City of Portland, Maine - Building or Use Permit Application

Job No: 2012-04-3655-ALTCOMM	Date Applied: 4/2/2012	CBL: 038- E-029-001	
Location of Construction: 19 SOUTH ST	Owner Name: G & L ENTERPRISES LLC	Owner Address: 19 SOUTH ST, #5 PORTLAND, ME 04101	Phone: 207-650-9686
Business Name:	Contractor Name: M & C Restoiraion & Remodeling - Marko Crnogorac	Contractor Address: 33 Candlewick Rd., Portland ME 04102	Phone: (207) 408-2158
Lessee/Buyer's Name:	Phone:	Permit Type: BLDG - Building	Zone: B-3
Past Use: Mixed use - 1 st floor 8 offices & 6 dwelling units above	Proposed Use: Same - Mixed use - 1 st floor 8 offices & 6 dwelling units above - build interior walls in part of basement to separate laundry room for tenants from rest of basement	Cost of Work: 2000.00	CEO District:
Proposed Project Description: Construct internal walls in part of basement for laundry room		Fire Dept: 5/23/12 Signature: Bjornwald (58)	Inspection: Use Group: 12/B Type: Signature: ABCOS

Job ID: 2012-04-3655-ALTCOMM

Located At: 19 SOUTH ST

Basement

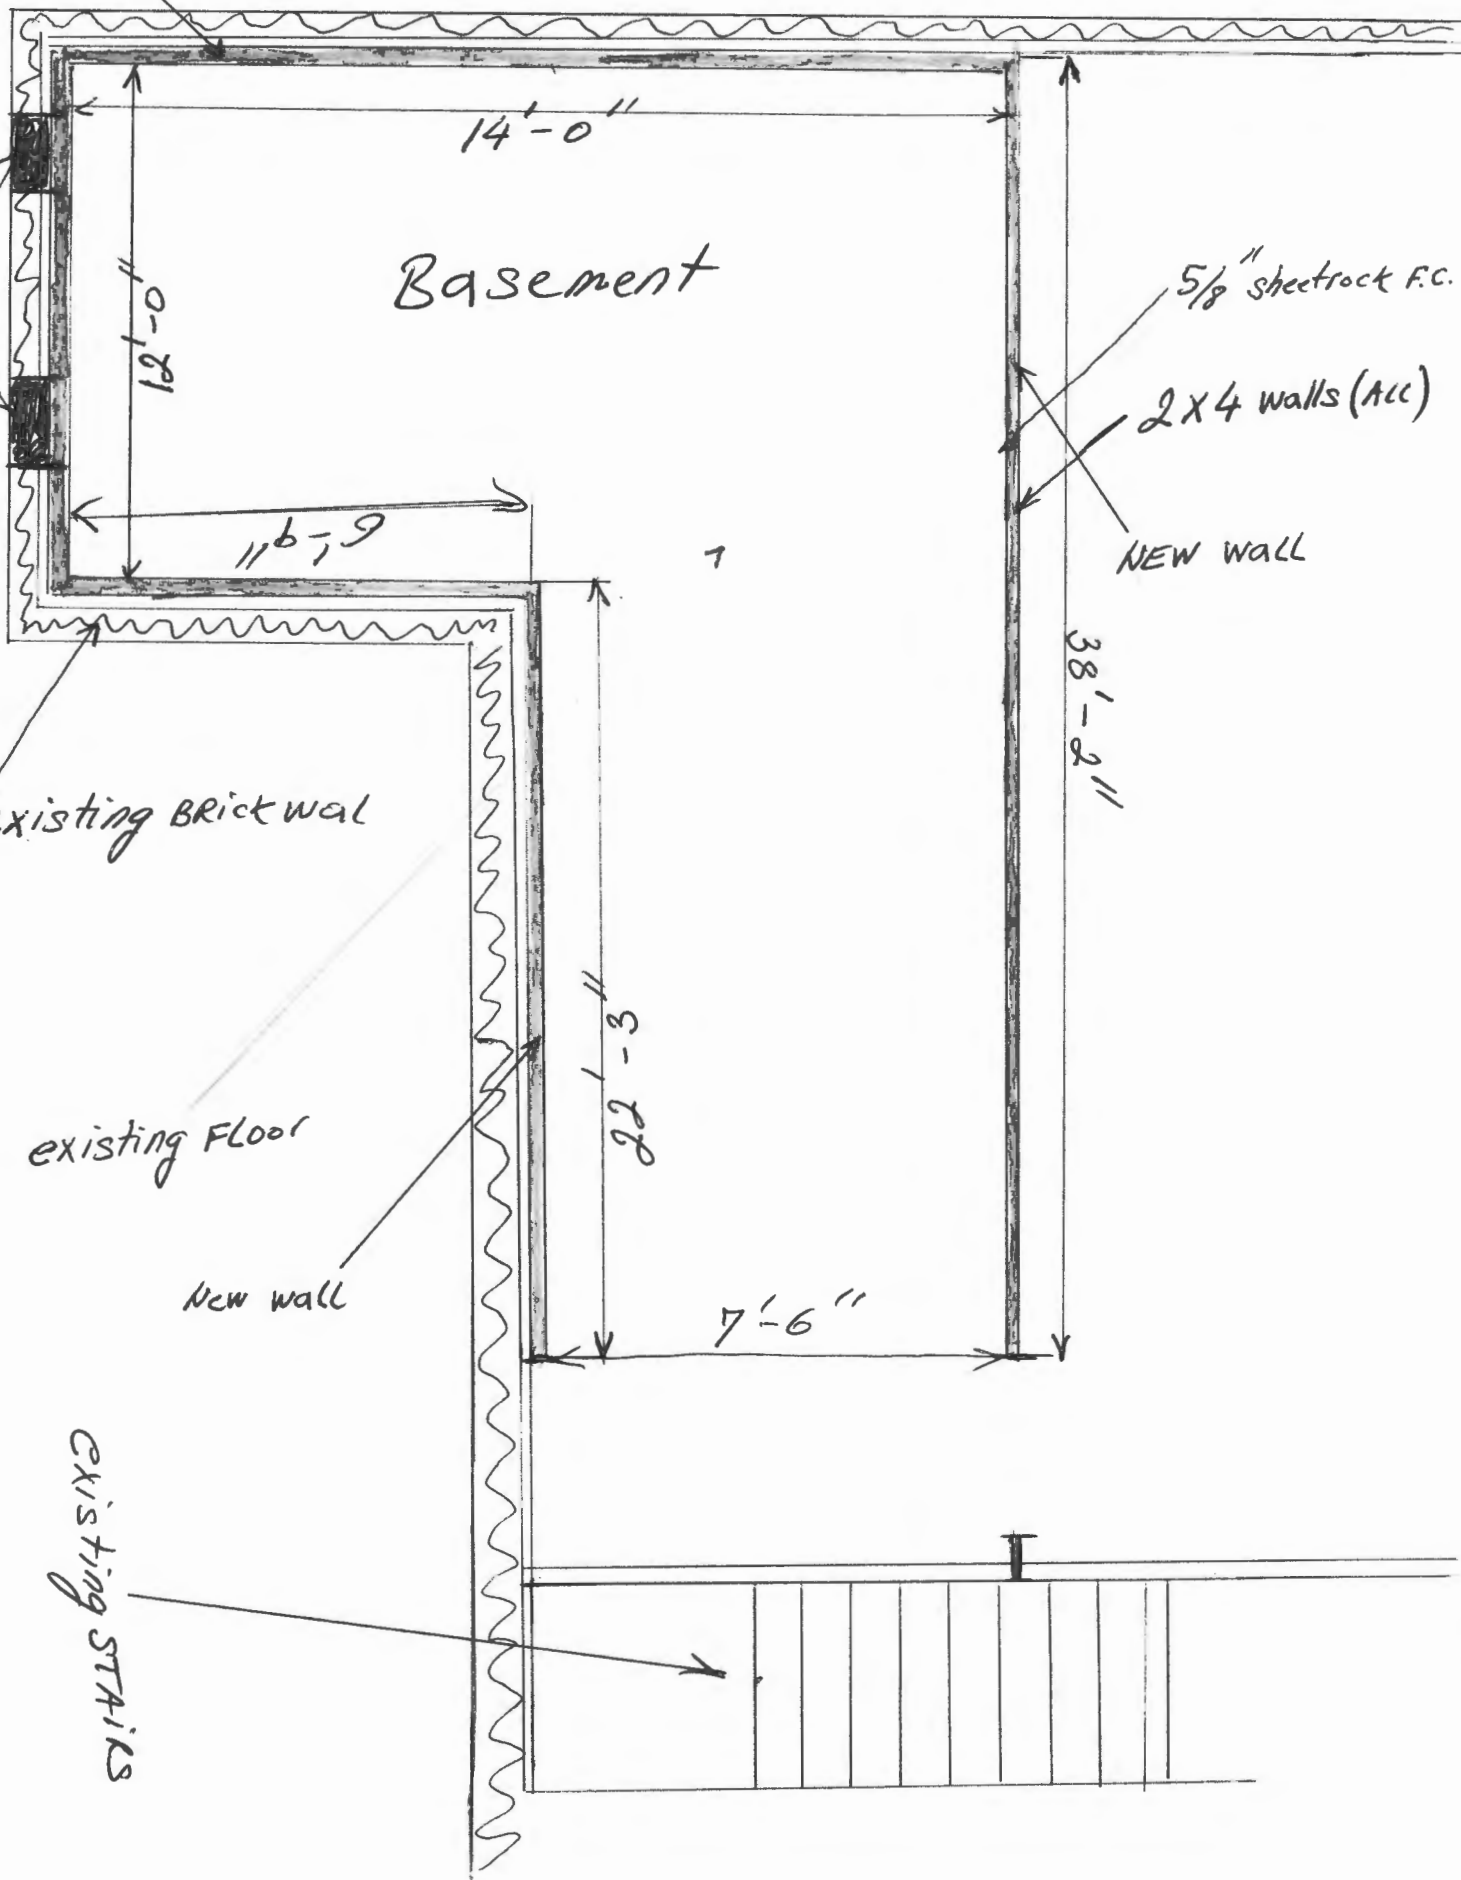
A 60-minute fire door assembly shall be installed at the top of the basement stair.

Common path of travel shall not exceed 35 feet.
